Re: Planning Application 19/0661

Address: Land at Petre Wood Close Langho BB6 8FD

Description: 31 affordable two and three-bedroom houses and two-bedroom bungalows (for rent and for shared ownership).

Simon Hardie
Highways Development Control
Lancashire County Council

Drawing file: planx_downloads / 19_0661_Proposed_site_plan.pdf

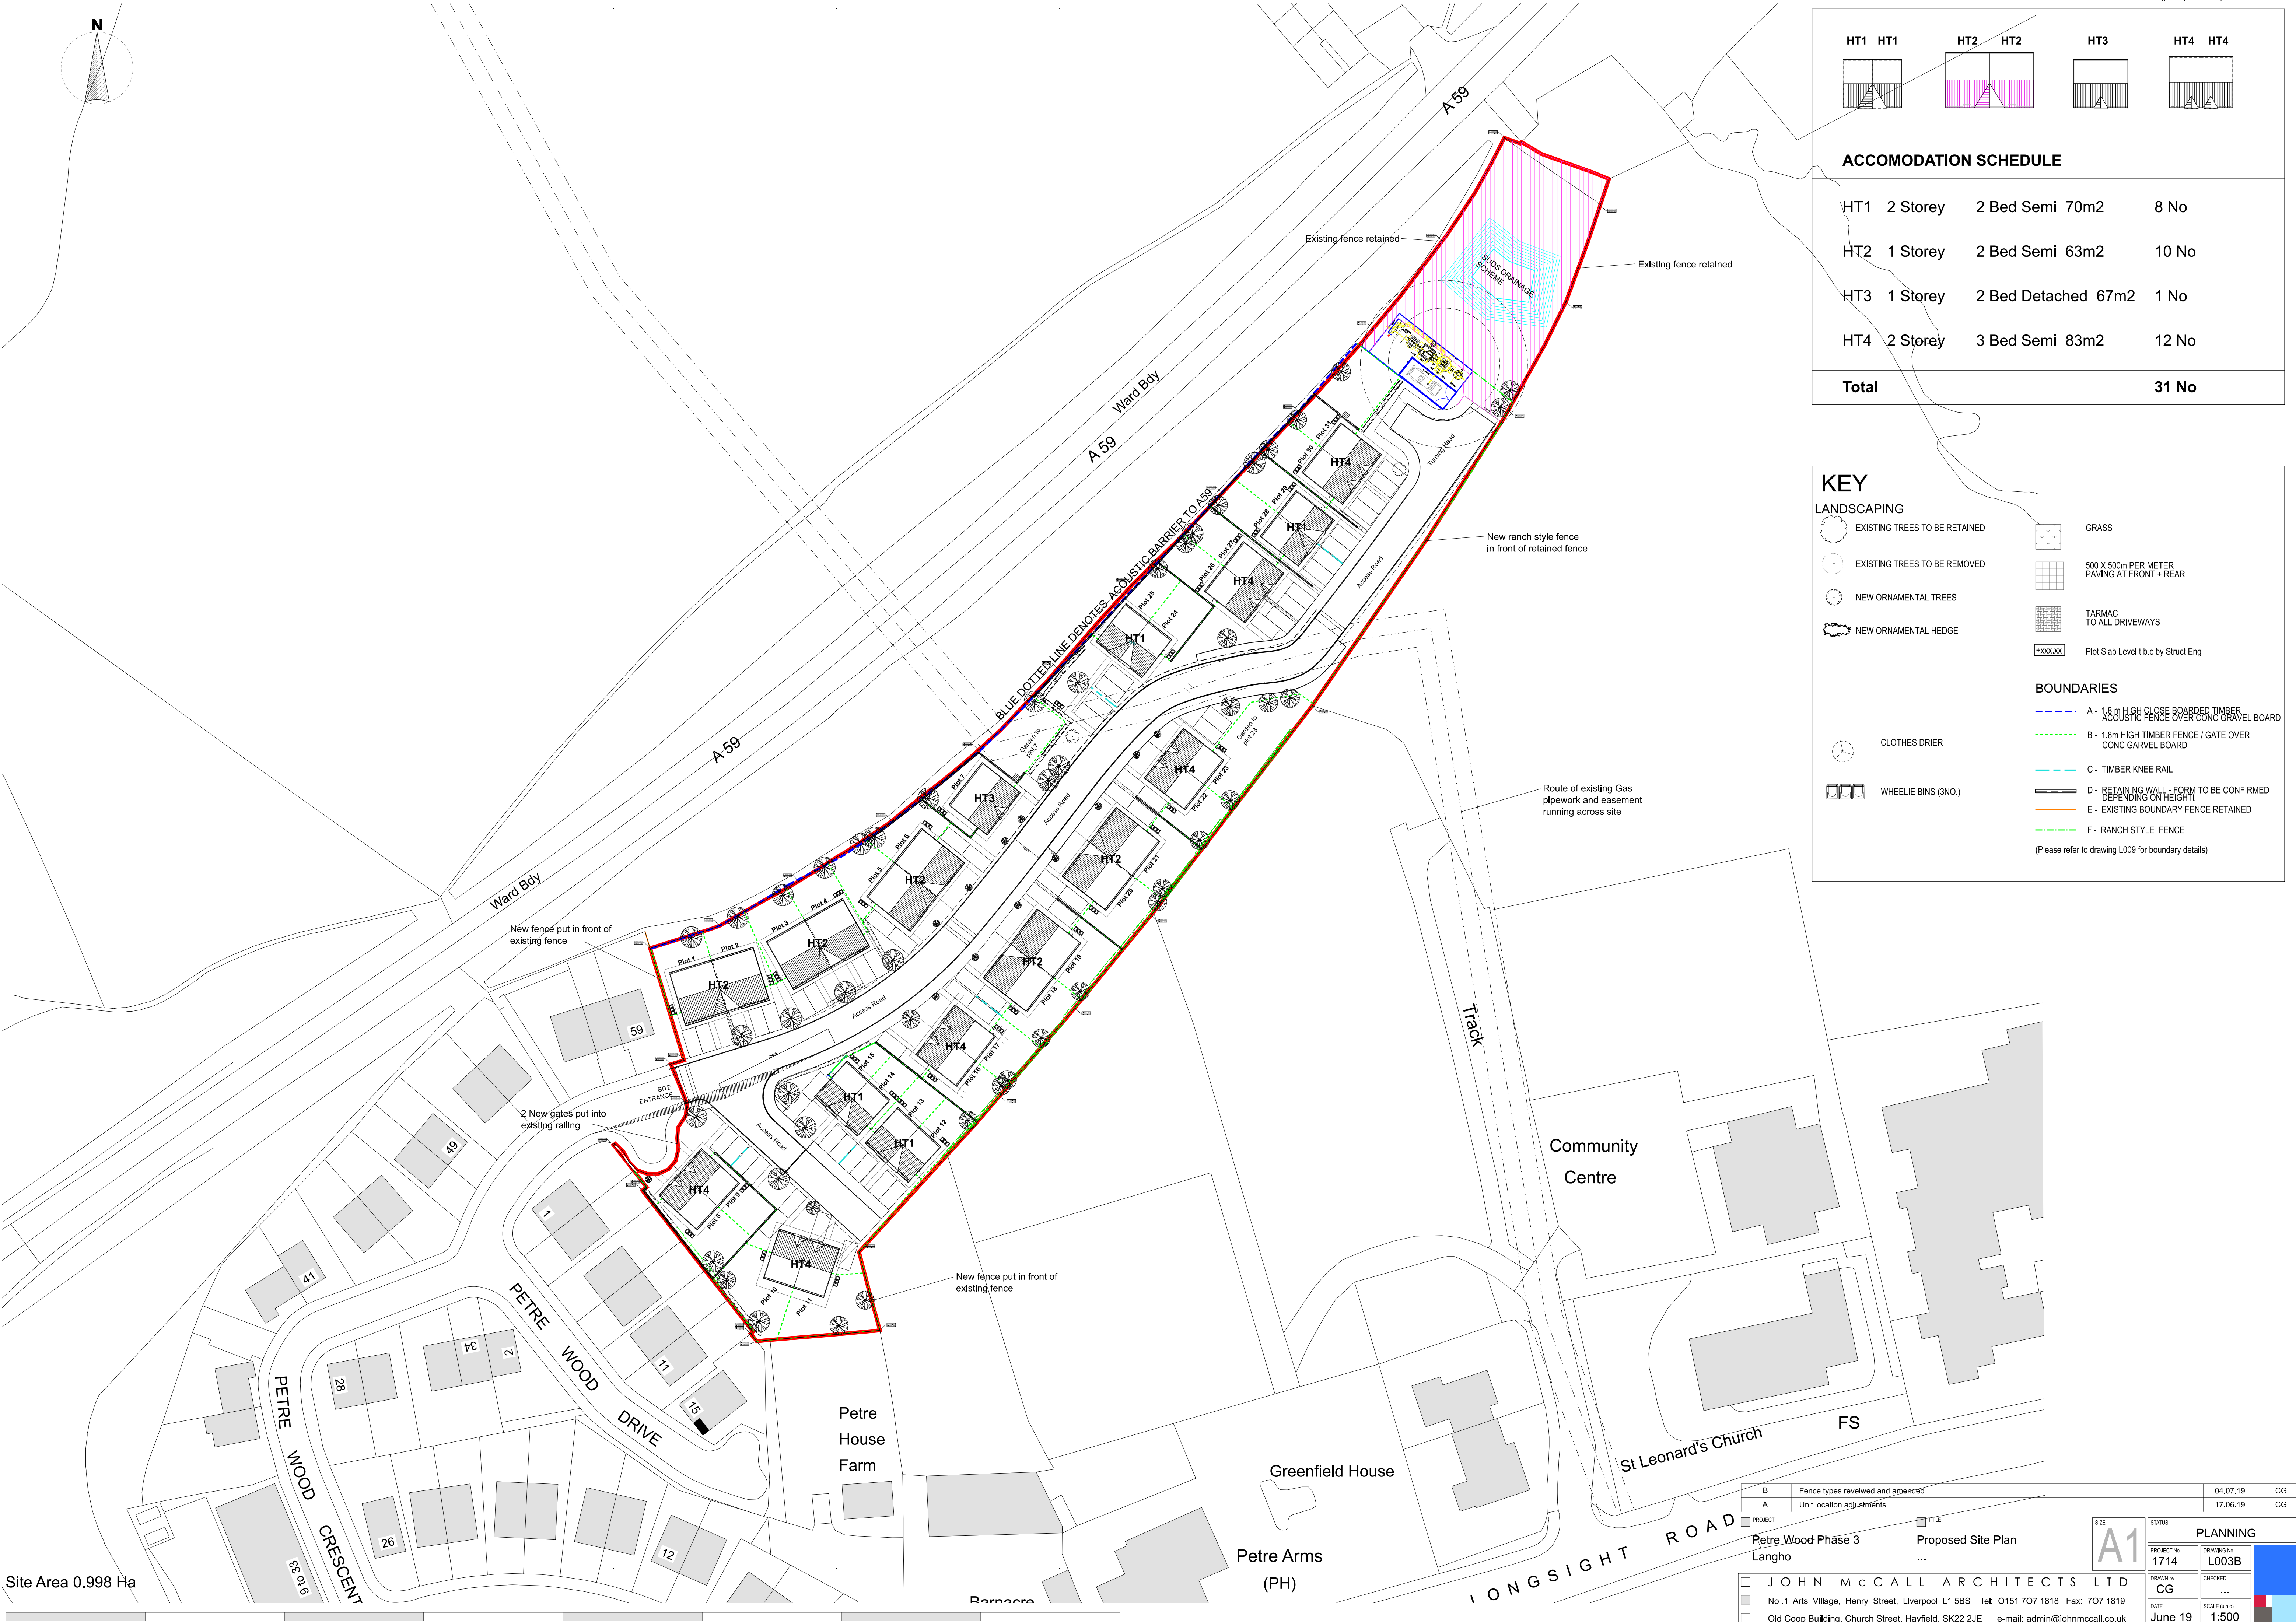
There are however a number of concerns regarding the site layout that will have to be addressed by way of a section 38 agreement. This is not intended to be a comprehensive list of all the issues that may be arising from this development, but shall include the following points,

- A 2m footway will be required for all carriageway that has properties fronting on to it
- A 0.5m service strip will be required for the remaining sections of carriageway
- A number of plots will require some further work to accommodate the required pedestrian access and the car parking spaces these should not occupy the same space, see Plots 10, 11, 15 and 16.
